A57 LINK ROADS TR010034

RESPONSE TO REP9-027 APPLICANT'S COMMENTS ON D9 SUBMISSIONS

CPRE Peak District and South Yorkshire

DEADLINE 10 – 5 May 2022

Figure 3-7 – Fixed Cost Function (FCF) area

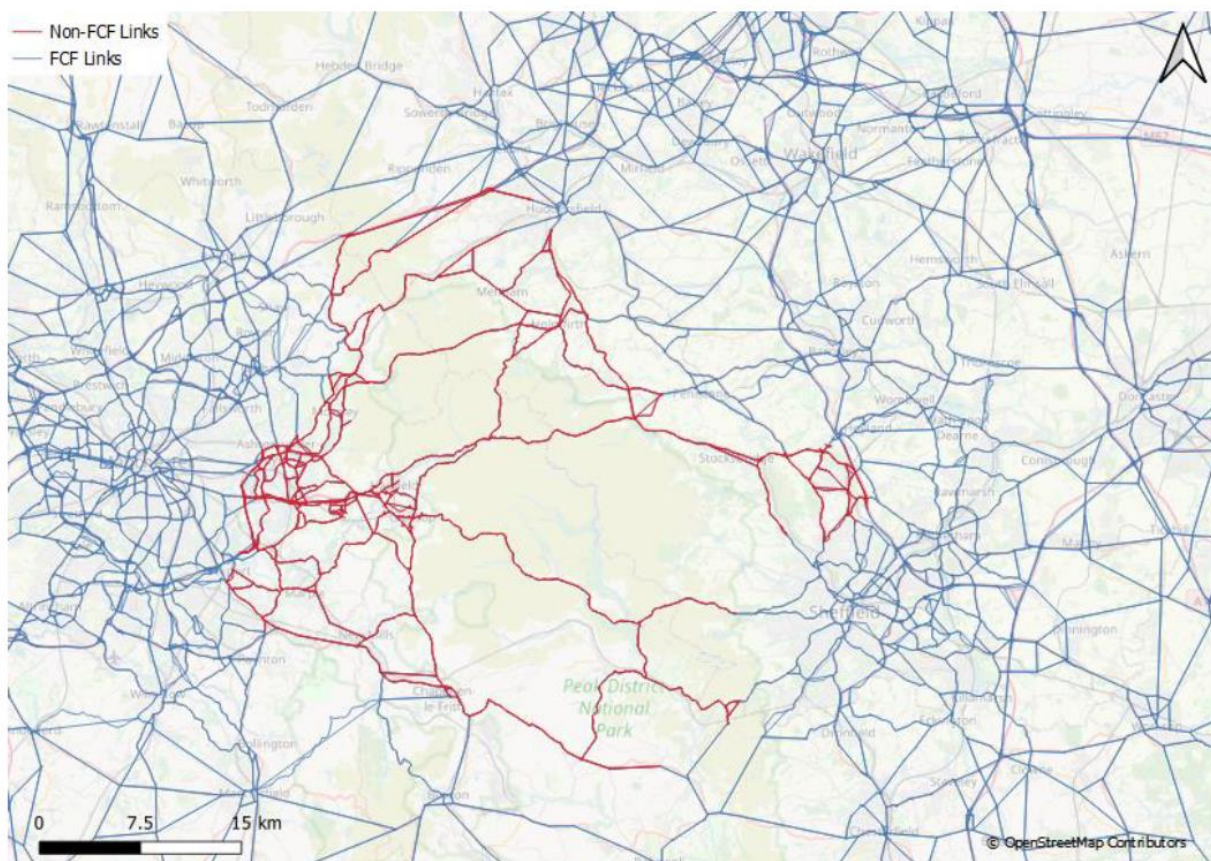
9.79.21 We have shown that the model does not represent the impacts of the scheme on transport networks in Greater Manchester. The scheme has been treated as an isolated bypass with limited access to Greater Manchester, with a fixed cost function and a masking approach applied to Greater Manchester.

NH responded: *It should be understood that the fixed-cost-function approach to modelling has been applied only to areas outside of the core region of influence of the scheme, as represented in Figure 3-7 of the Transport Forecasting Package. This does not apply to the whole of the Greater Manchester area as has been suggested. The metropolitan boroughs of Tameside (except for the small section to the west of the M60), Stockport and the majority of Oldham are within the area of detailed modelling and fixed costs do not apply in these areas.*

We have taken Figure 3-7 showing the fixed cost function in REP2-090 page 289/790 and overlain the three borough boundaries (see figure below). From this we estimate that the fixed cost function was applied to the majority of Oldham, 20% of Tameside and 40% of Stockport boroughs and these areas were therefore excluded from the ADM. Thus NH's claim appears misleading.
